From: Elizabeth Downing
To: Michelle Niles
Cc: Anthony Witherdin
Subject: RE: 3A07/1004-02 Response to Submission - MP 05_0024 MOD 4
Date: Friday, 25 May 2018 12:57:32 PM
Attachments: image001.jpg
image002.png

PLAN SHOWING PROJECT APPLICATION FOR PROPOSED STAGED RESIDENTIAL DEVELOPMENT OF LOT 171 DP1081810 AT HIGHVIEW DRIVE, DOLPHIN POINT FOR MALBEC DOLPHIN POINT PTY LTD

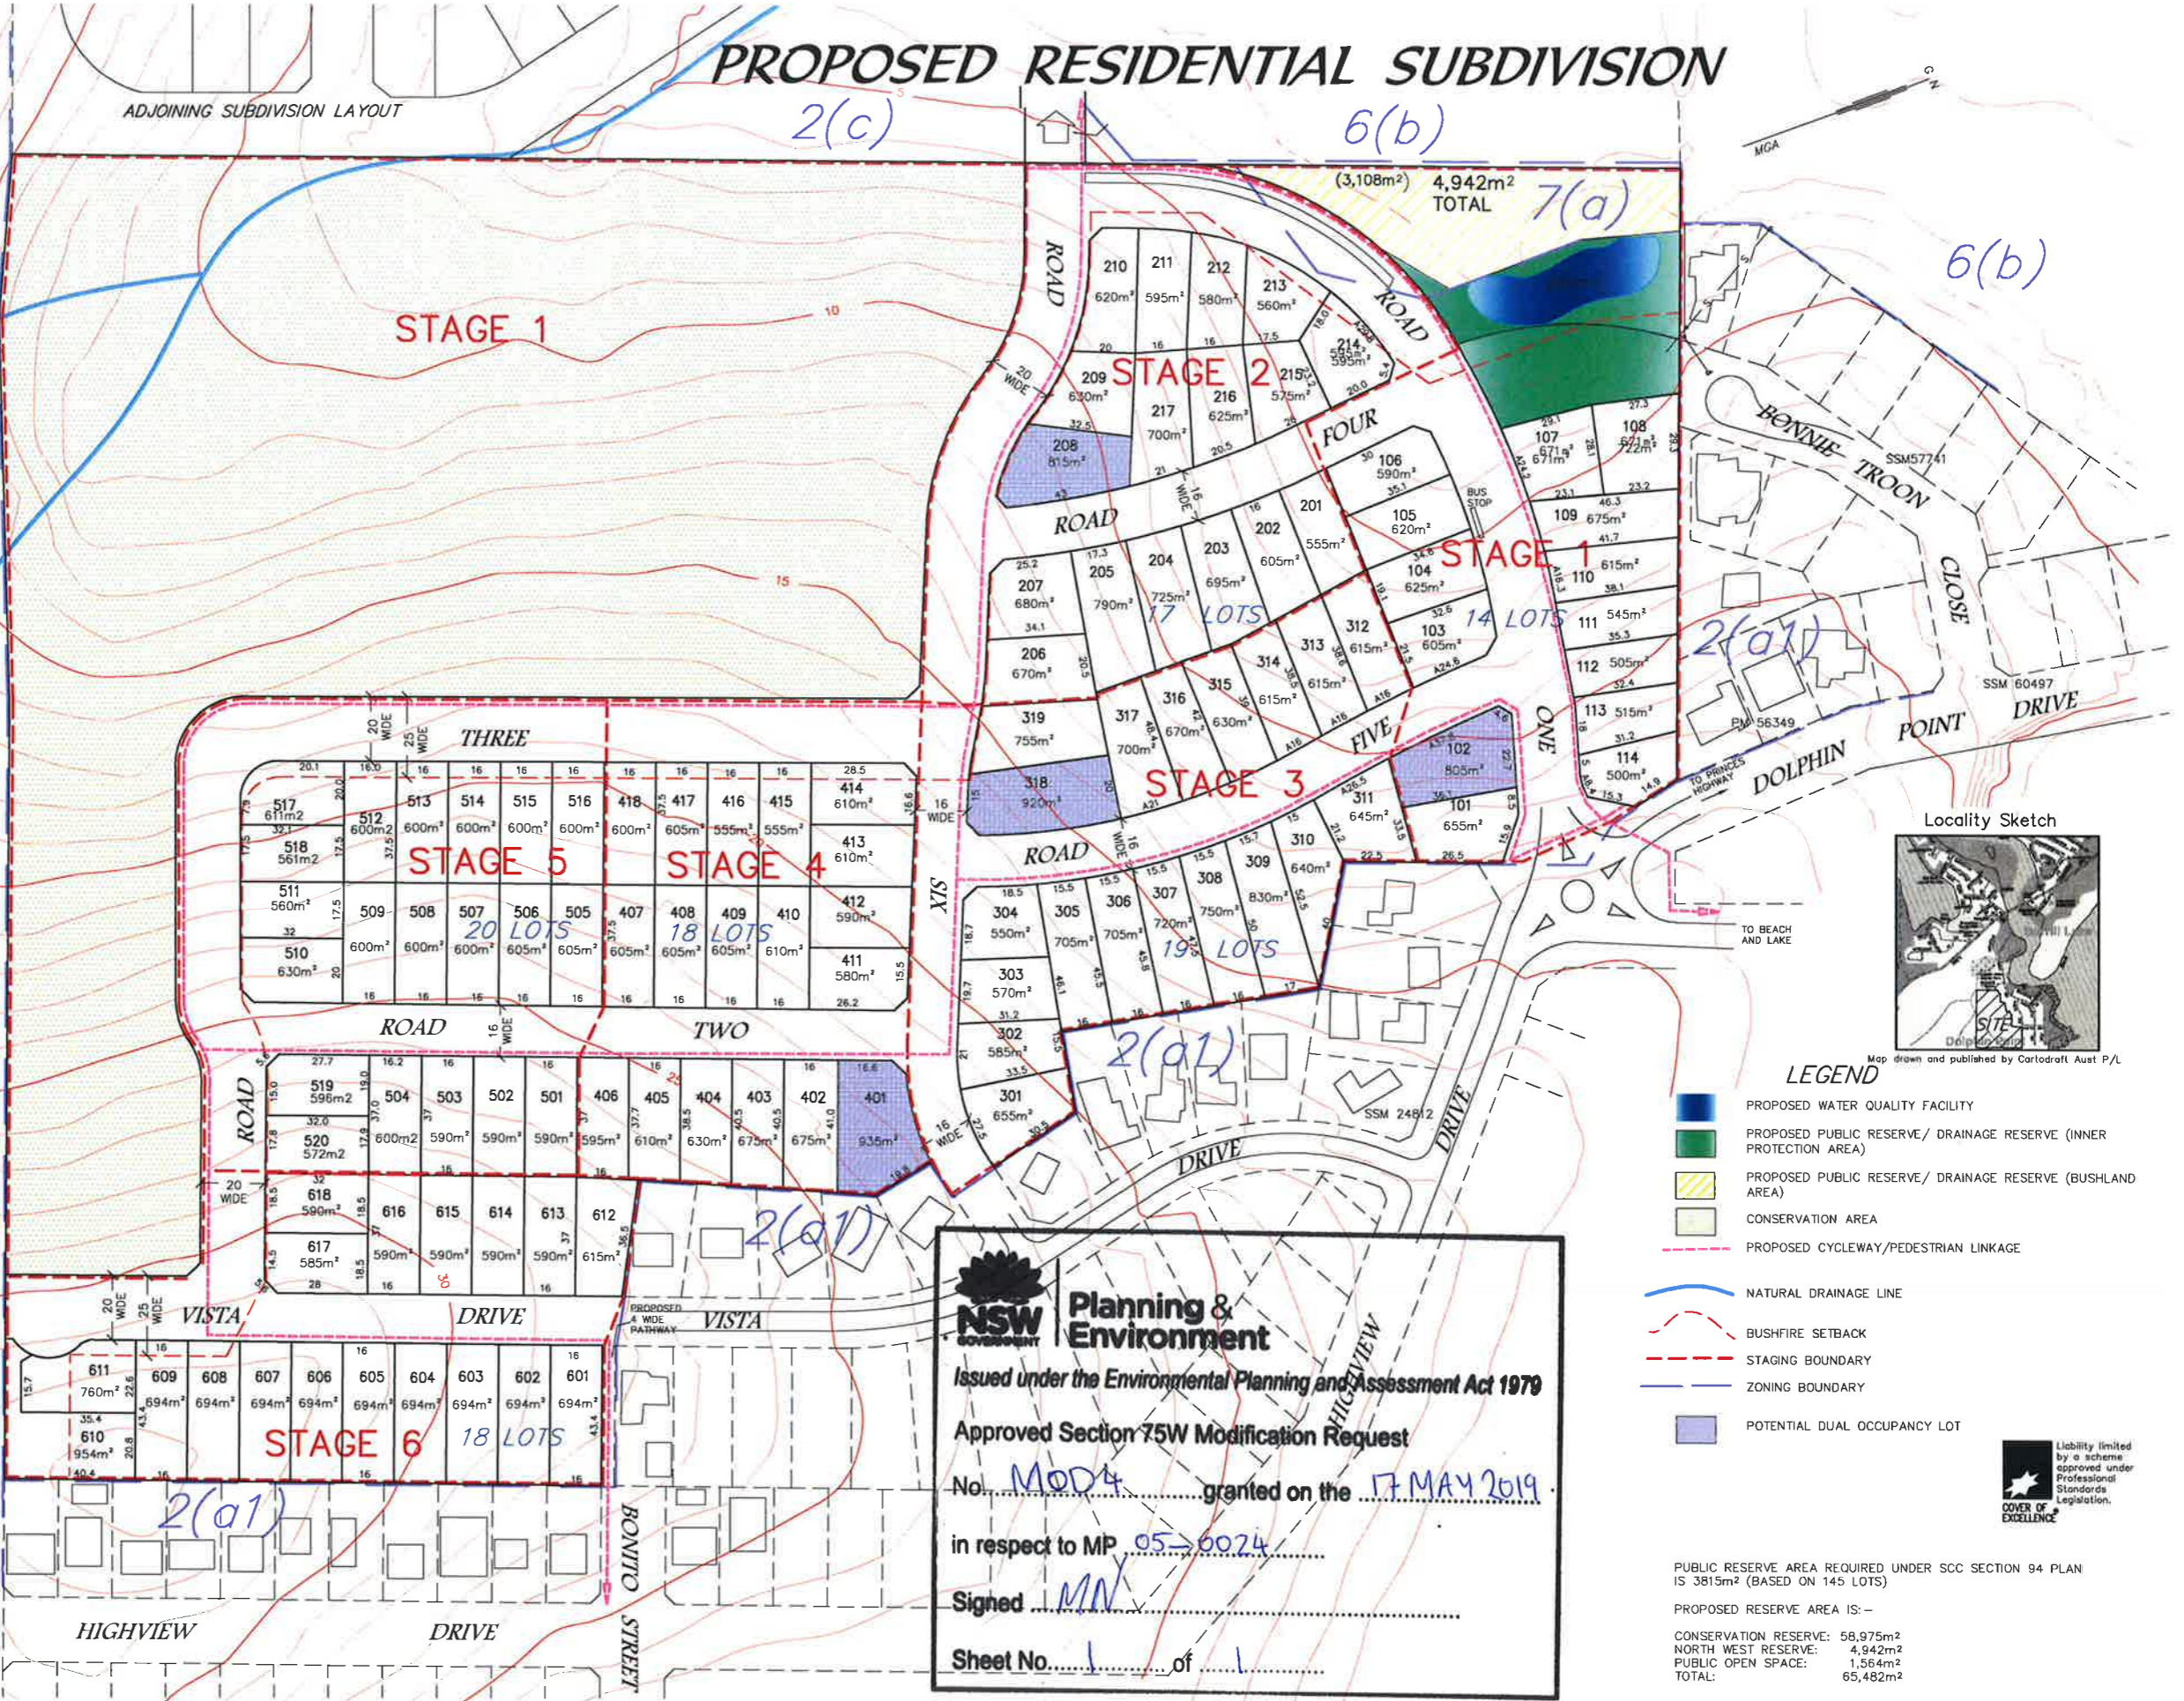
As stated previously in Council's comments to these alterations in February 2018 (doc no. D18/44482), although the conservation area has been increased, no buffer was included between the development area and the locations of recorded individuals/populations of either the Leafless Tongue orchid or White-footed Dunnart. As such, although there is a lesser impact to these species, impacts still include; edge effects, the removal of known habitat and the potential loss of individuals.

The modified subdivision design does not include the appropriate buffers to the known populations of White-footed Dunnart and Leafless Tongue Orchid to remove all potential edge effects. This was previously highlighted in Section 6.8 of the Environmental Assessment Report (Cowman Stoddart, 2007). The continuation of the monitoring programs for these species is beneficial as a mitigation measure as was previously determined (BES 2007) and thus contained within in the DA approval commitments.

If the DA approval commitments relating to the White-footed Dunnart and Leafless Tongue Orchid were to be removed, then additional conditions would replace them in line with an updated assessment providing mitigation measures. These mitigation measures would require a buffer (as stated above from the original assessment by BES in 2007) around these populations and the inclusion of a Management/Monitoring Plan for the Leafless Tongue Orchid and a separate Management/Monitoring Plan for the White-footed Dunnart population within the Conservation Reserve to mitigate those indirect impacts associated with edge effects.

Council can agree that the conditions relating to the translocation of the Leafless Tongue Orchid may be removed; however, given the above-mentioned reasons and advice from Lesryk Environmental relating to the ongoing monitoring and/or management of Leafless Tongue orchid and White-footed Dunnart, council retain the position of opposing the removal of commitments relating to these effects. This is summarised in the below table."
